CITY OF ALBUQUERQUE

Re: MAS Charter School
Neighborhood Impact Assessment, HT#L16D037
Report dated November 2022
Engineer's Stamp 11/03/2022

The subject Neighborhood Impact Assessment (NIA) received November 3, 2022, has been reviewed and accepted by the City of Albuquerque Planning Development Transportation Section. The NIA will be valid for three years from date of approval. If changes to the development plans impact traffic or after three years the recommended improvements have been not built or permitted for construction the NIA may need to be reassessed by the City.

Yale Boulevard under West and Community Center Loops Alternative

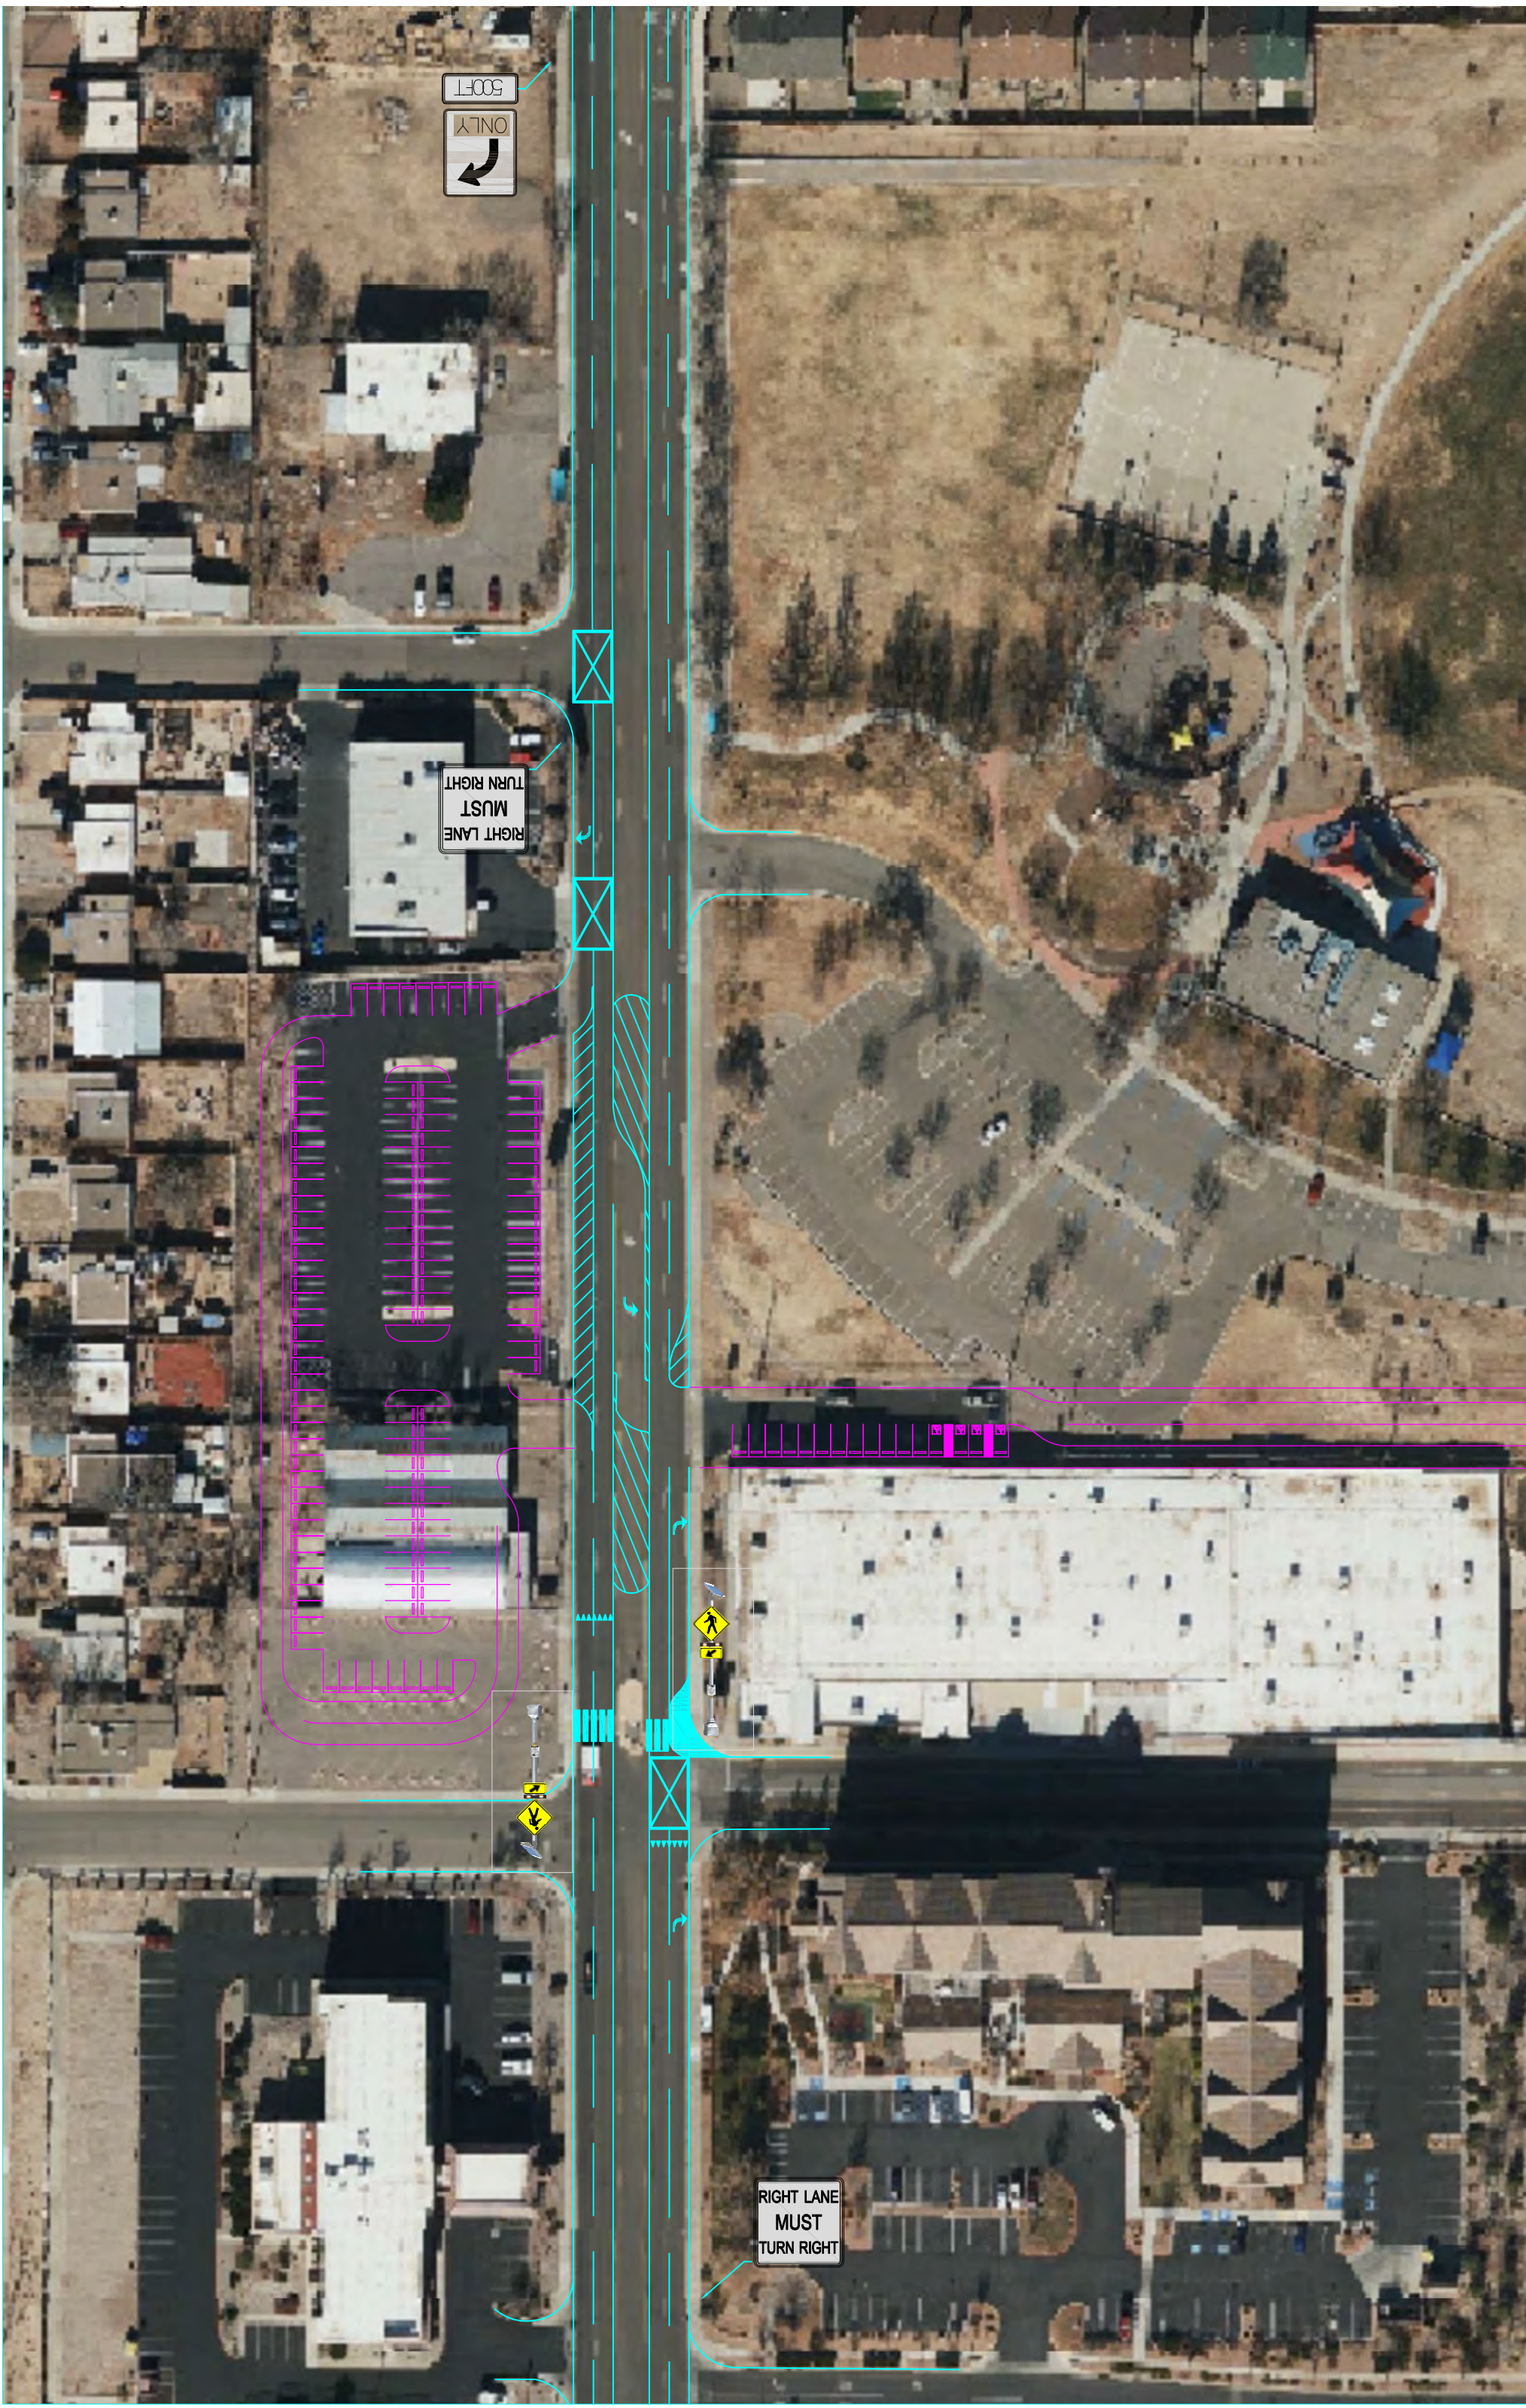
Recommendations for Community Center Loop Alternative

- For the Community Center Loop establish a median treatment to restrict left-turns from northbound traffic to access Driveway 2 while allowing southbound traffic to complete left-turns to access Driveway 3.
- For the Community Center Loop, auxiliary right-turn lanes are established on Yale Boulevard for Driveways 1 and 3.

Yale Boulevard under West and Ross Loops Alternative

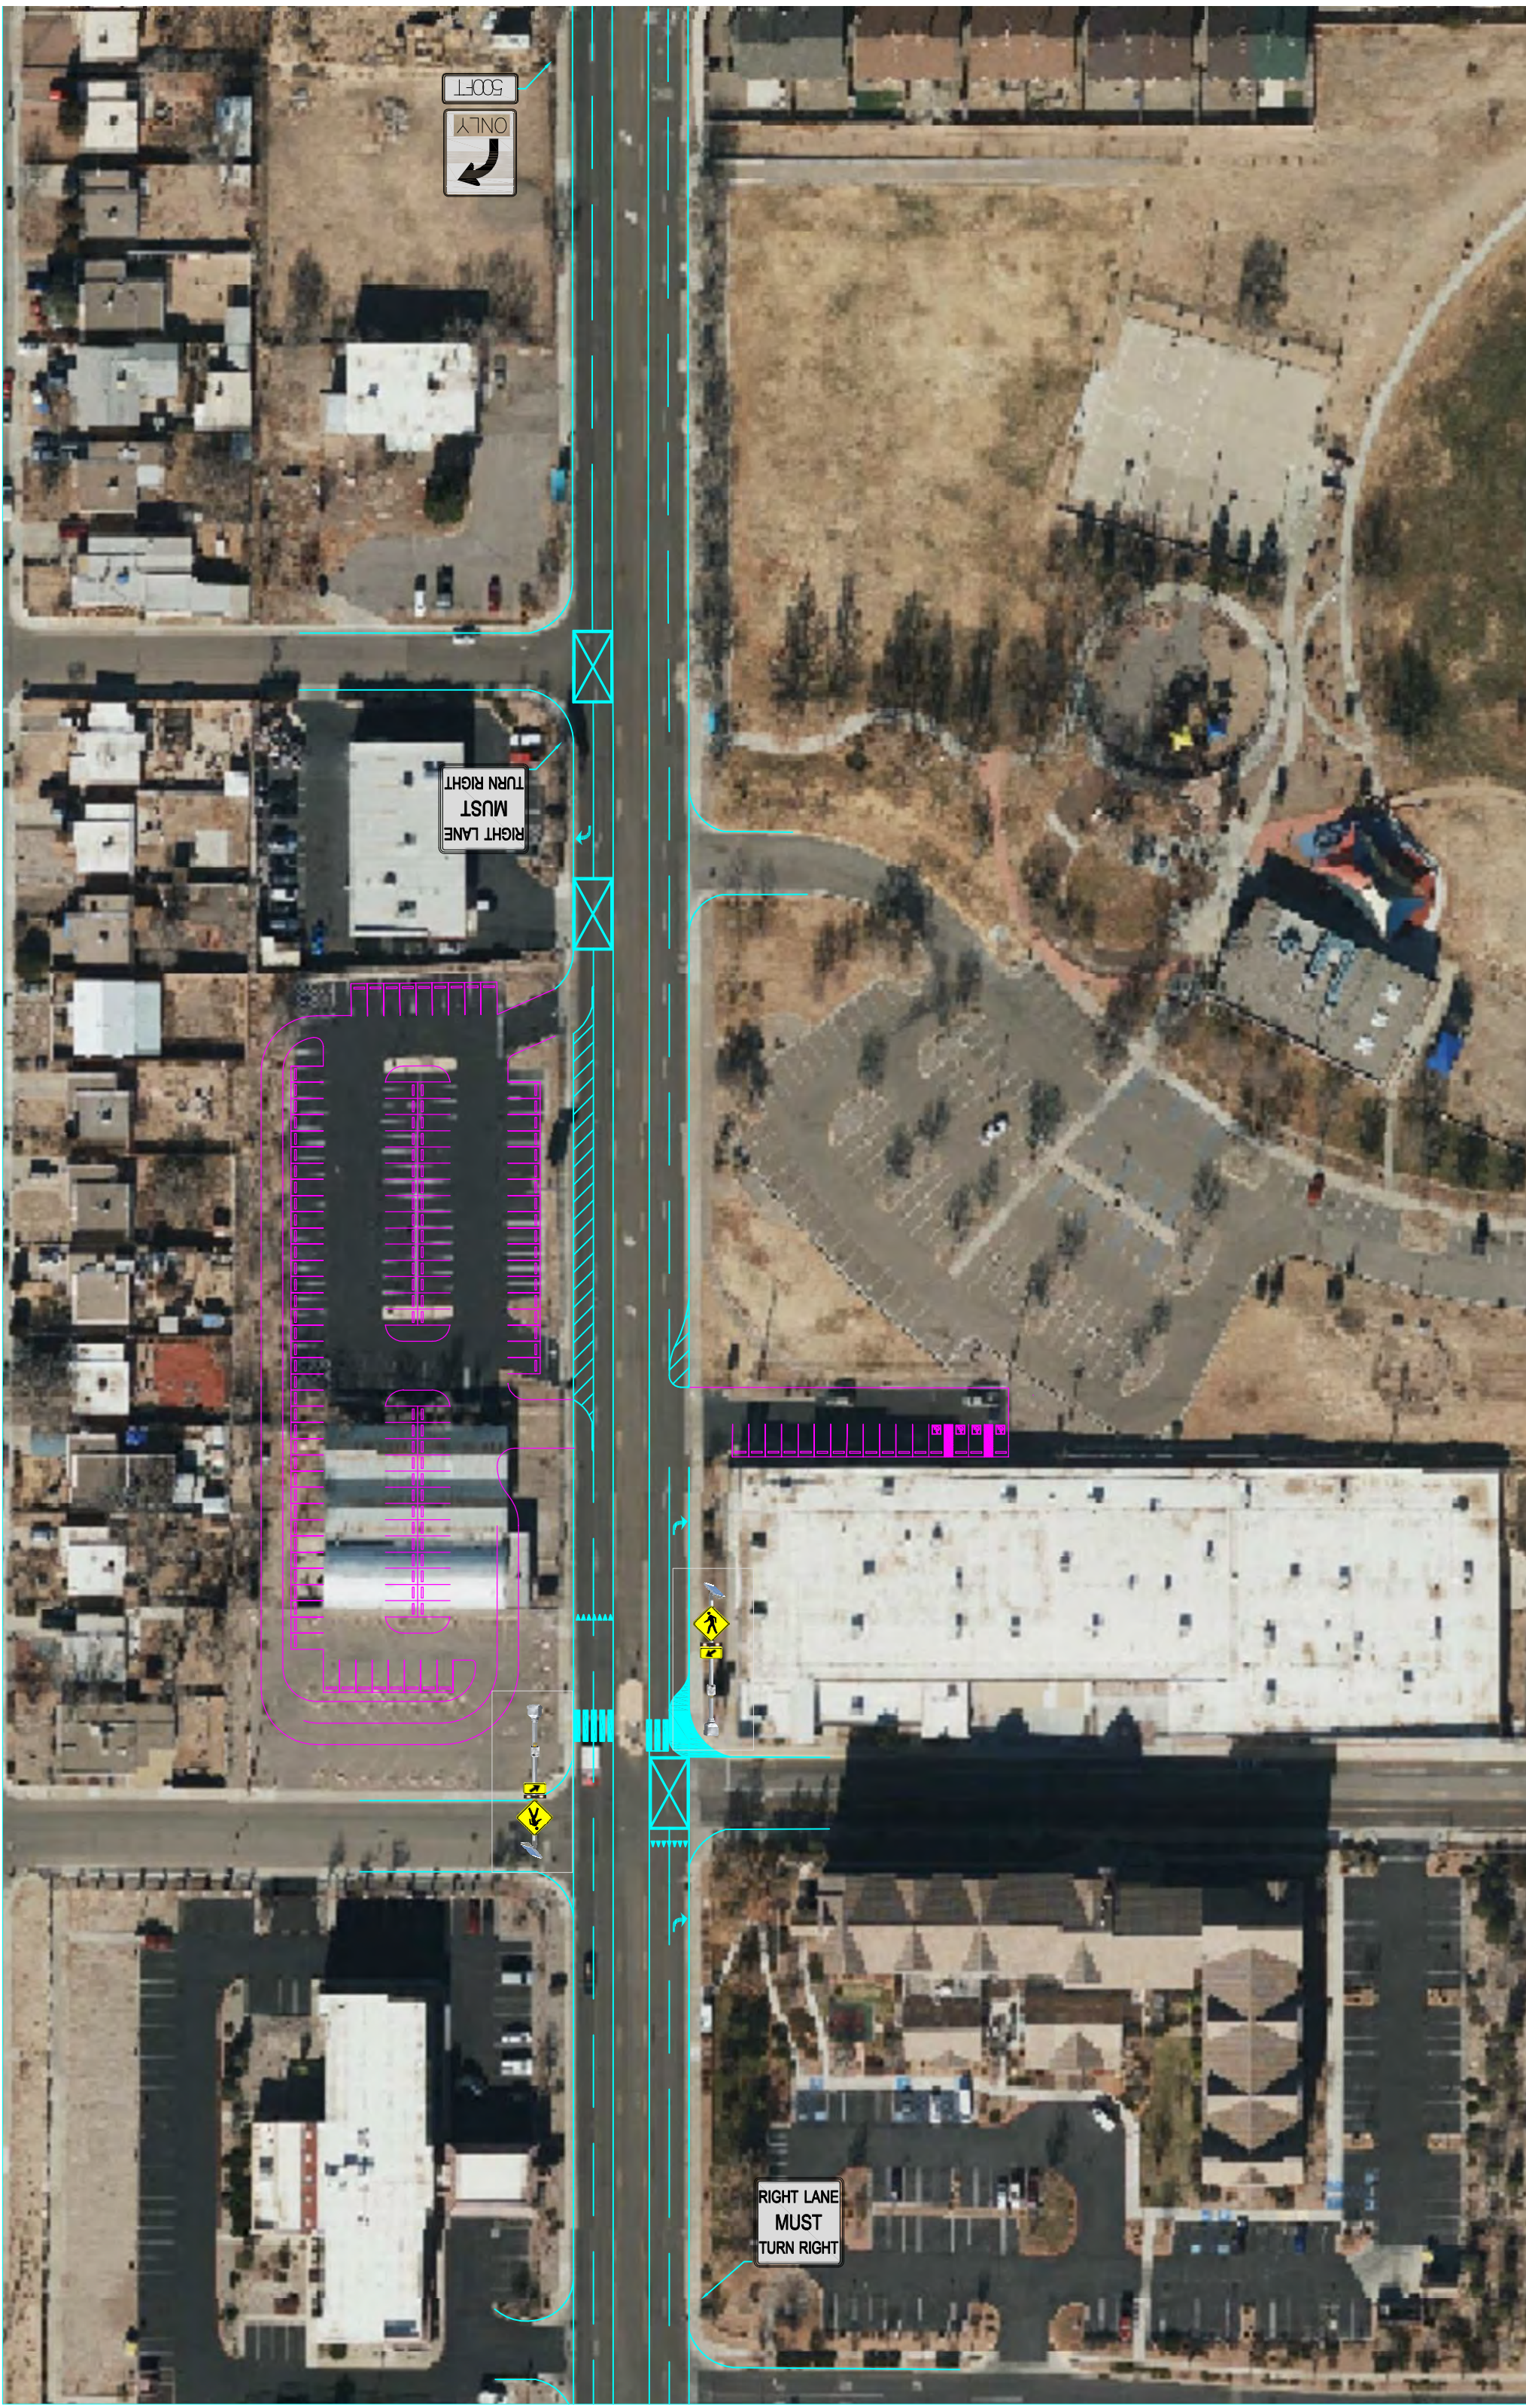
Recommendations for West Loop Alternatives

- Blocking the business's driveway, north of Driveway 1, is prohibited. Do Not Block Intersection pavement markings shall be applied, communicated to parents, and firmly enforced.
- An exclusive right-turn lane should be striped on northbound Yale Boulevard between Ross and International Avenues per the CABQ DPM for the West Loop alternatives.
- Access to the site is maintained via the drop-off/pick-up operations map provided in the report.
 - Driveway 1 - right-in only
 - Driveway 2 – right-out only
 - Driveway 4 – right-out only
- Stripe a through/right turn lane on Yale Boulevard for Driveway 2 egress.
- Install plastic bollards between the turn and through lanes at Driveways 1 and 2 to communicate the right-in, right-out access of these driveways.
